**WELWYN HATFIELD BOROUGH COUNCIL
EXECUTIVE DIRECTOR - PLANNING, PUBLIC PROTECTION AND GOVERNANCE**

DELEGATED APPLICATION

Application No: 6/2021/2126/PN8
Location: 35 Northaw Road East Cuffley Potters Bar EN6 4LU
Proposal: Prior approval for the erection of a single storey rear extension measuring 8m in depth, 3.804m in height and 3.674m to the eaves
Officer: Ms Emily Stainer

Recommendation: Refused

PROPOSED REAR ELEVATION

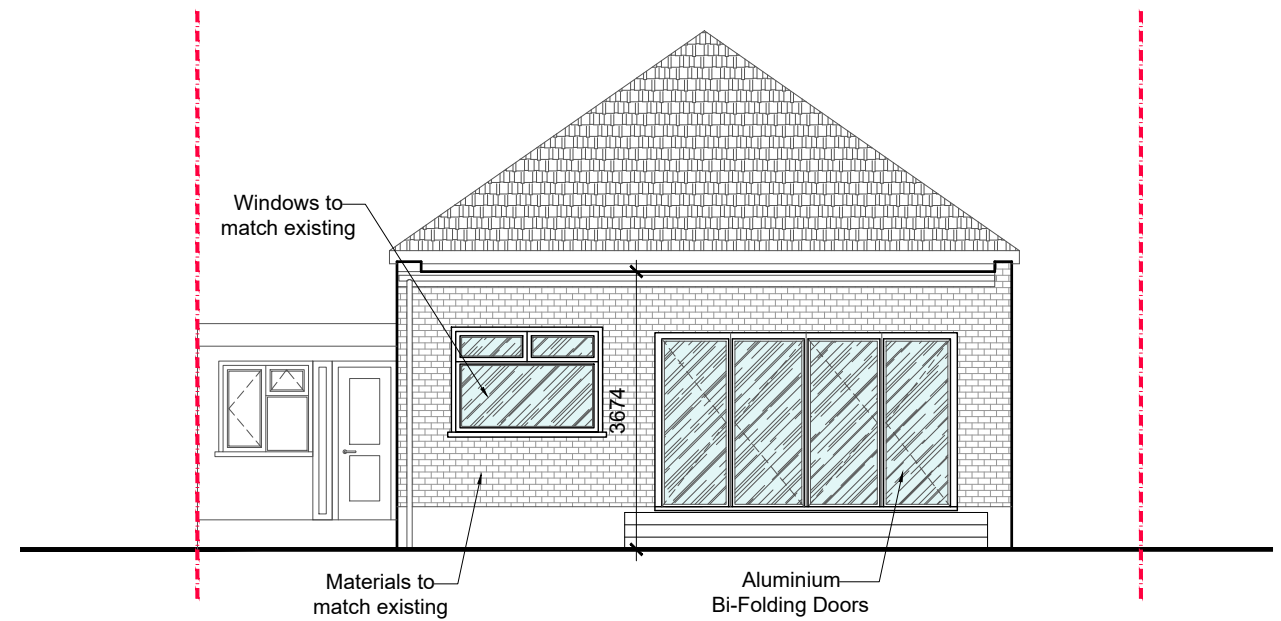
The proposed rear elevation drawing indicates the boundary of the site in red, which is located approximately 1.6m away from the flank wall of the proposed extension and the boundary with 33 Northaw Road East. The submitted floor plans also show that at its closest point, the extension would be approximately 1.3m away from the boundary with 33 Northaw Road East. The eaves height is described on the application form as being 3.67m above ground floor level, with the total height of the extension measuring 3.8m. At its highest section of ground, the external wall of the existing property would meet the upper surface of the roof slope at approximately 3.2m above ground level (as indicated on the side elevations). As such, the enlarged part of the dwellinghouse would be within 2 metres of the boundary of the curtilage of the dwellinghouse, and the height of the eaves of the enlarged part would exceed 3 metres.

The height of the eaves (taken from the upper surface of the flat roof) of the proposed extension would exceed 3m in height and the enlarged part of the dwellinghouse would be within 2 metres of the boundary of the curtilage. The proposal therefore fails to comply with Schedule 2, Part 1, Class A.1 (i), of the General Permitted Development Order 2015 (as amended).

PROPOSED SECTION AA

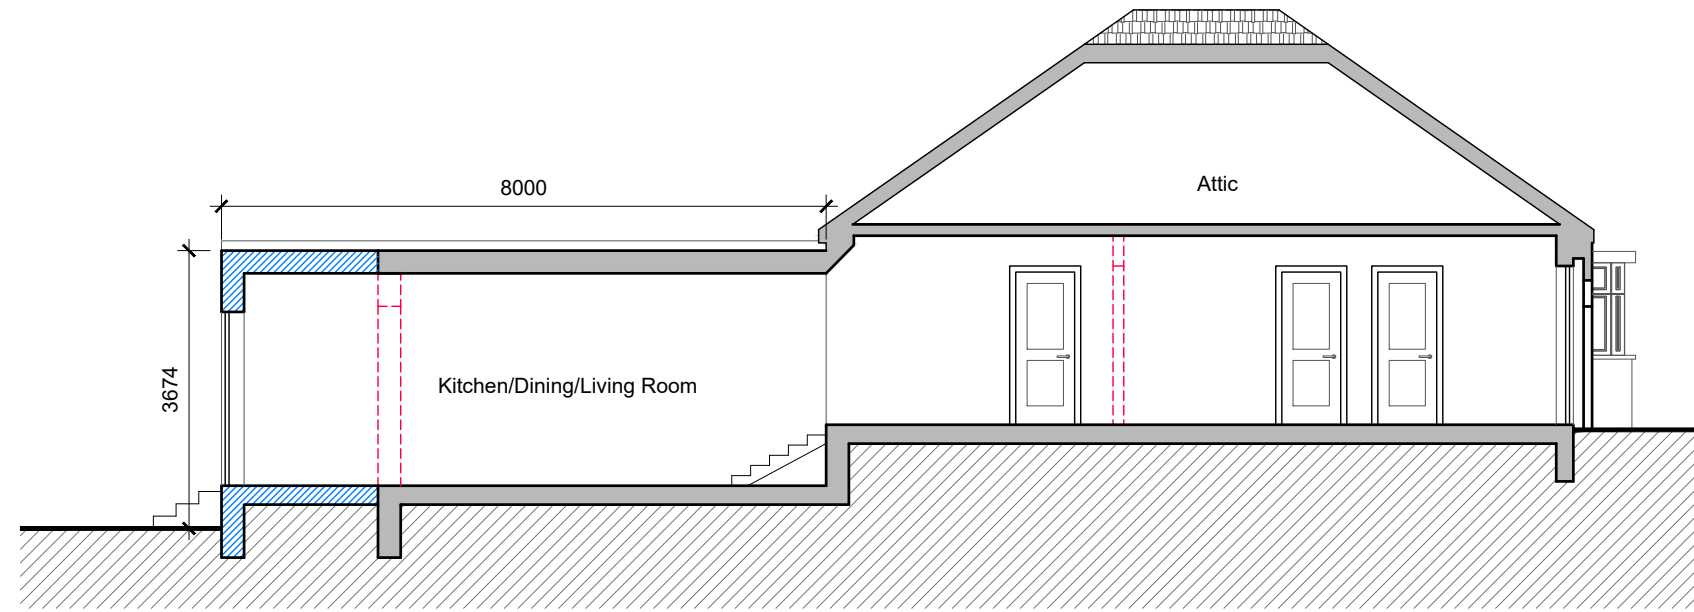
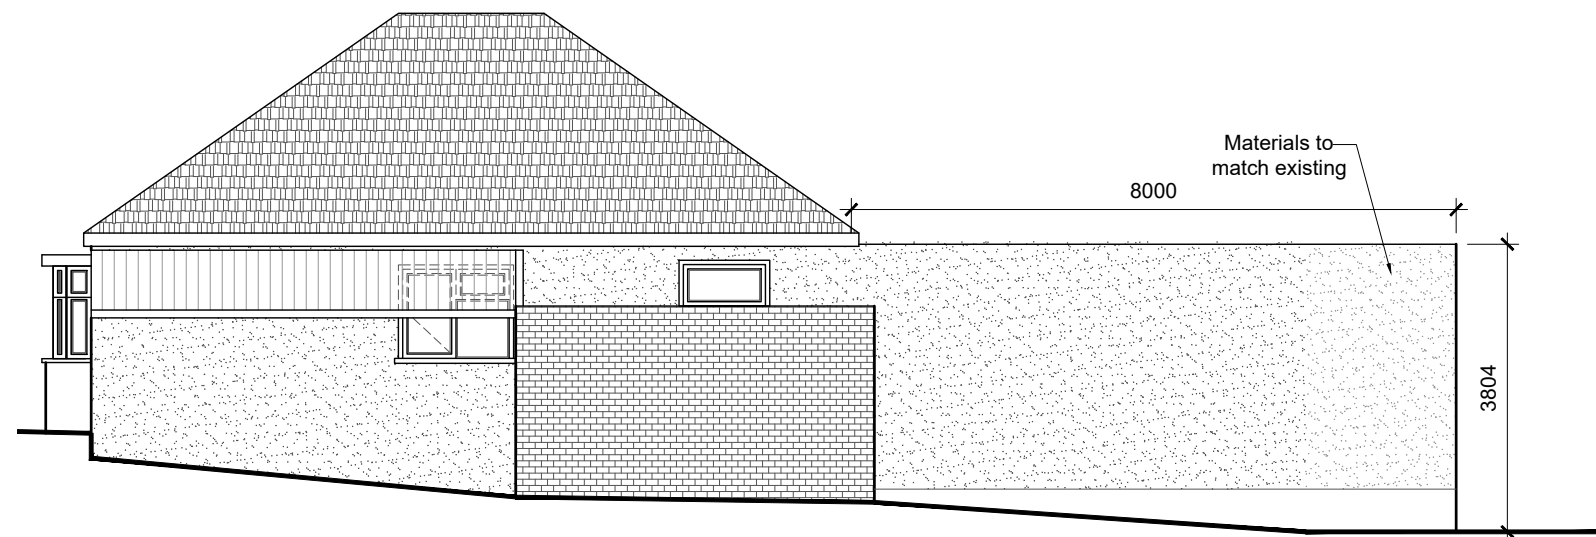
(c) where the enlarged part of the dwellinghouse has more than a single storey, or forms an upper storey on an existing enlargement of the original dwellinghouse, the roof pitch of the enlarged part must, so far as practicable, be the same as the roof pitch of the original dwellinghouse	N/A	Y
Discussion		
<u><i>Eaves height</i></u>		
Development is not permitted under Schedule 2, Part 1, Class A.1 (i) of the General Permitted Development Order 2015, as amended (GPDO) if the enlarged part of the dwellinghouse would be within 2m of the boundary of the curtilage with the dwellinghouse, and the height of the eaves of the enlarged part would exceed 3m.		
The Householder Technical Guidance document (September 2019) states that for the purpose of measuring height, the eaves of a house are the point where the lowest point of a roof slope, or a flat roof, meets the outside wall. The height of the eaves will be measured from the ground level at the base of the outside wall of the extension to the point where the external wall would meet the upper surface of the roof slope. Parapet walls and overhanging parts of eaves should not be included in any calculation of eaves height.
